Ref: 7 Little Drive, Ferring, BN12 5RF

FG/94/20/HH

Please accept our formal objection herein to the planning application FG/94/20/HH.

For • Mr. & Mrs. K. King
D.R.G. • 19/14/3.A.
SCALE : 1/50. A.2019.
DATE : DEC. 2019.

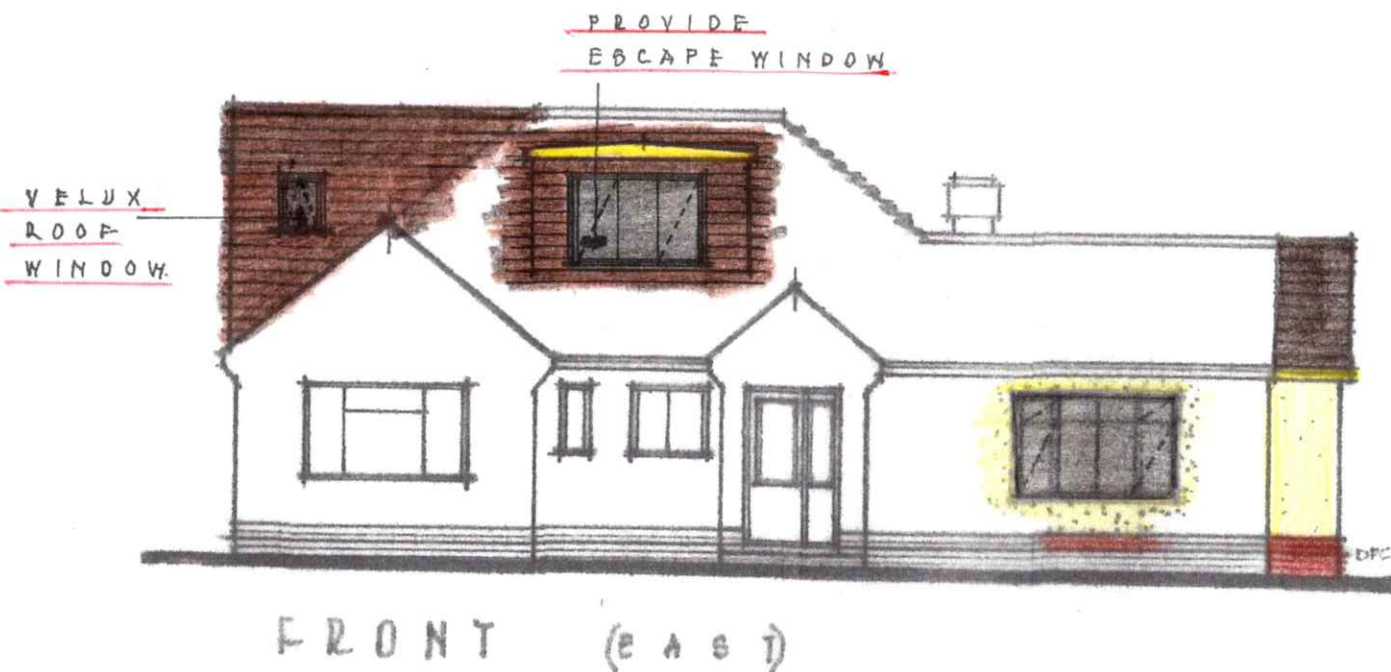
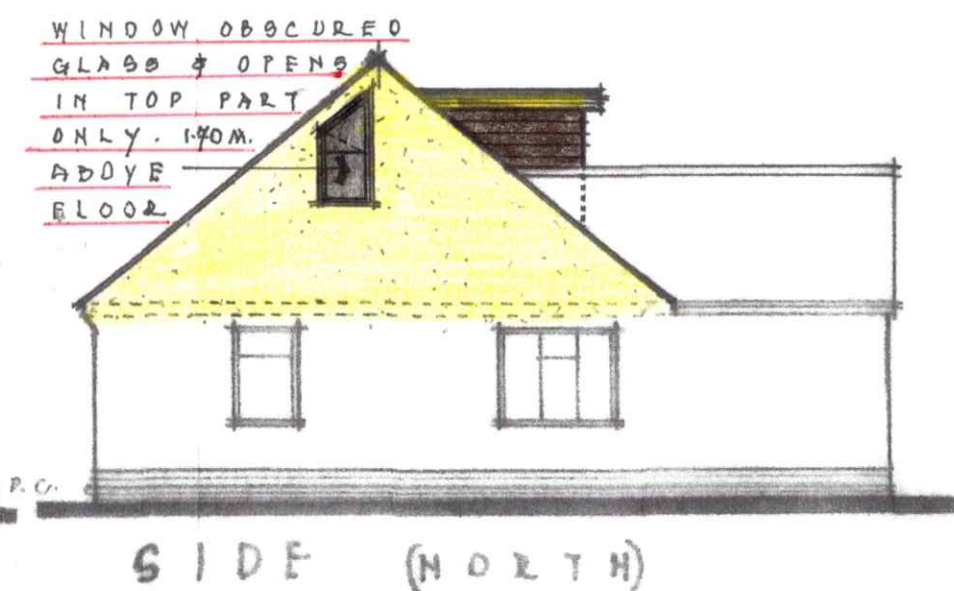
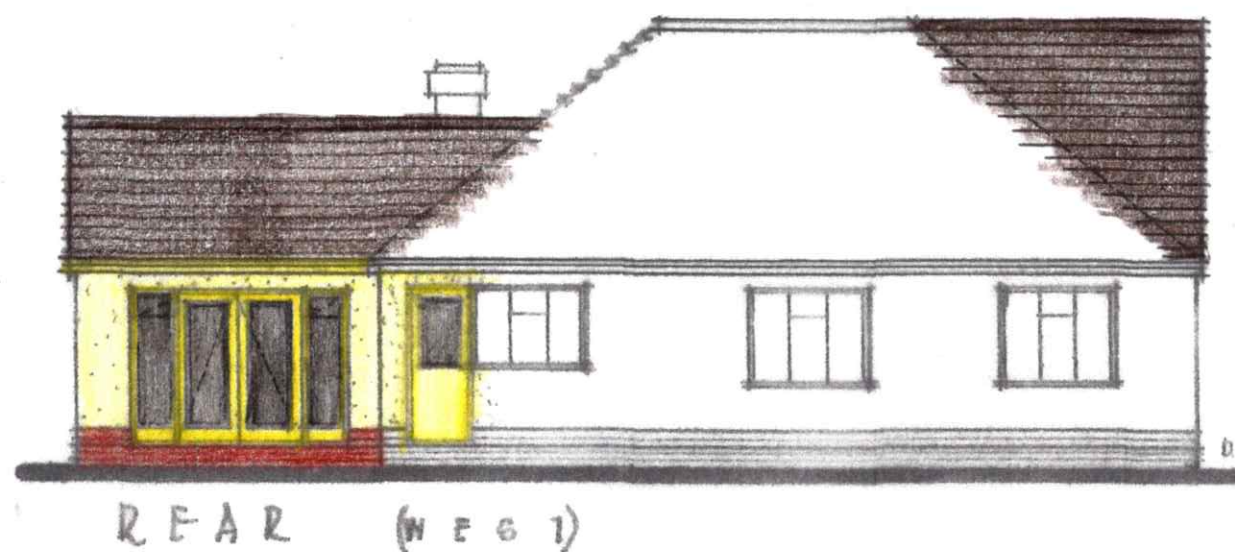
We have examined the plans submitted and would now like to formally object to the planning application of number 7 Little Drive due to the fact that the dormer in the front of the property is a direct invasion of our privacy.

We live at 11 Little Drive which sits on a corner plot positioned in front of number 7 Little Drive. The dormer will look directly into our back garden leaving no area where our family will be allowed any privacy; it also has direct sight into the master bedroom window and my daughter's bedroom requiring blinds to be drawn to maintain privacy and incurring a loss of light as a result. The front dormer will also peer directly into our side lounge window and is completely out of character for all neighbouring and adjacent bungalows in Little Drive.

We have lived in Little Drive for over five years and are aware there is a covenant on the bungalows which includes number 7, that does not allow windows being put into the roof. No other bungalows in Little Drive have put in dormer windows in their roof which significantly overlook and invade another bungalows privacy in this cul de sac, especially one that overlooks a neighbouring property to all primary aspects of their property, as it would do to 11 Little Drive.
